PSA-18-005

PRELIMINARY SITE ANALYSIS

Preliminary Site Analysis Report

PSA #: PSA-18-00509 **Map #:** 20-15-22000-0002
Issue Date: 11/27/2018 **Expiration Date:** 11/27/2019
Parcel #: 863034 **Site address:** None
Owner: ELWARD, JON
56614 MORELAND AVE NE
ATLANTA, GA, 30307
Proposed use: sfr

SITE PLAN

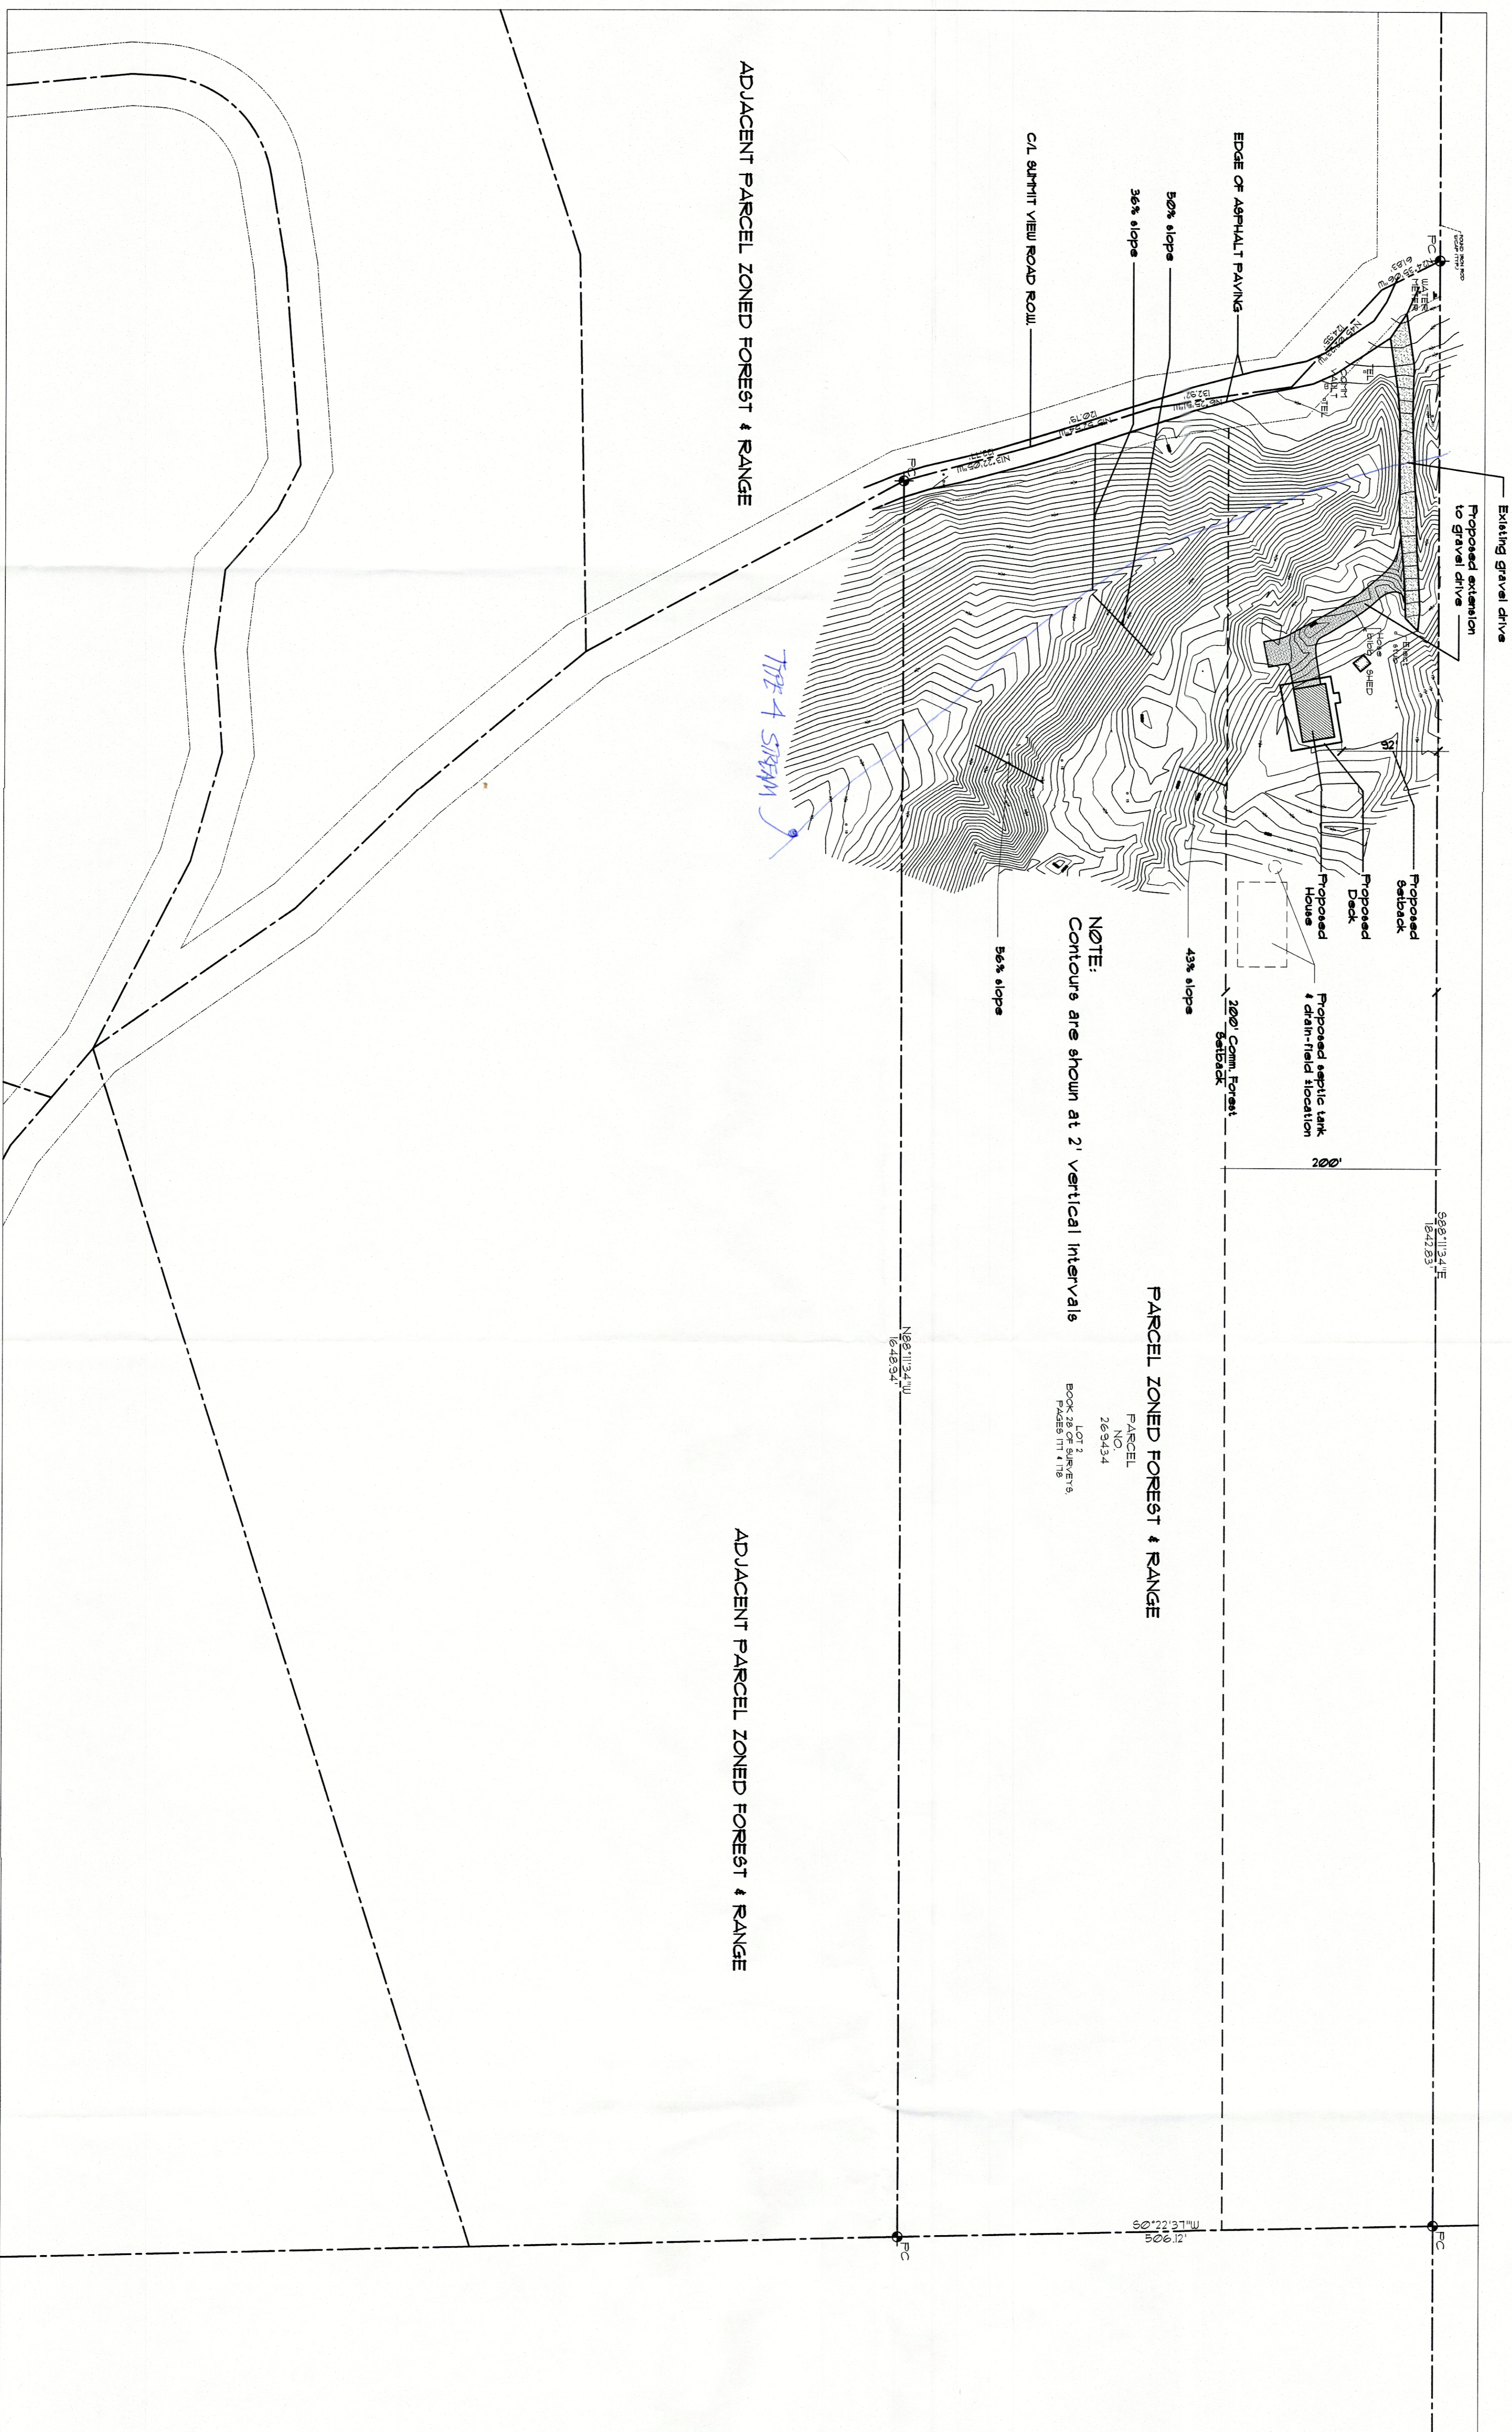
Lot size: 20.00 a
Land use: Commercial Forest, Allowed Use
Zoning: Forest and Range
Setback: Front: 25
Setback: Side: 10
Setback: Rear: 10
- This parcel borders a Commercial Forest Zone which requires a 200 foot setback from the property line (Northern property line) that borders the Commercial Forest Zone.
In a platted development?: No
Urban Growth Area?: No
Airport overlay: No
BPA: No
Forest Practices Act: No
Mineral lands: No

- There is a Type 4 stream on the subject property. The Type 4 stream has a 15 foot setback landward from the OHWM. The streams and setback/ buffer must be shown on the site plan at the time of building permit submittal. If you are proposing to build within 100 feet of the OHWM of the stream you will need to contact CDS planning for more information. Note: Kittitas County is currently updating its Critical Areas Ordinance. As of January 1, 2019 these setback distances may change. Please consult CDS after January 1, 2019 to ensure your project meets the required critical area setbacks.

- ENGINEERING TO USE EXPOSURE FACTOR 1.2 FOR SHELTERED AREA USE EXPOSURE "B" FOR SHELTERED AREA THE SITE CONDITIONS EXCEED 33.3% SLOPE. A DETAILED TOPO MAP TO VERIFY SITE CONDITIONS SHOWING SETBACKS FROM THE TOE AND BASE OF THE SLOPE IS REQUIRED. A GEOTECHNICAL EVALUATION WILL BE REQUIRED IF THE STRUCTURE DOES NOT MEET THE MINIMUM PRESCRIPTIVE SETBACKS. PLANS MAY NEED BOTH ENGINEERED SOILS ANALYSIS AND STRUCTURALLY ENGINEERED STAMPED PLANS AT TIME OF SUBMITTAL. HOME OWNER MUST VERIFY THIS INFORMATION BEFORE SUBMITTING A BUILDING PERMIT APPLICATION. SITE PLAN SUBMITTED FOR BUILDING PERMIT MUST BE TO SCALE AND MEET THE MINIMUM REQUIREMENTS OF THE UNIFIED SITE PLAN.

SEE ATTACHED WUIC AND DEFENSIBLE SPACE REQUIREMENTS. AREA OF DEFENSIBLE SPACE MUST BE OUTLINED ON SITE PLAN SUBMITTED FOR BUILDING PERMIT. IF THIS STRUCTURE CONTAINS HABITABLE SPACE, ADDITIONAL DEFENSIBLE SPACE WILL BE REQUIRED. YOU MAY BE ABLE TO MITIGATE BELOW THE IR RATING BY APPLYING FOR THE WUIC APPLICATION. NON-HABITABLE SPACES MORE THAN 50 FEET FROM HABITABLE SPACES DO NOT REQUIRE SPRINKLERS. PLEASE TELL US IF ANY PORTION OF THIS SHOP WILL BE USED FOR HUMAN HABITATION OR IT WILL BE CLOSER THAN 50 FEET TO HABITABLE SPACES.

| Comments: | Please verify that site plan used for building permit submittal shows all required elements. |
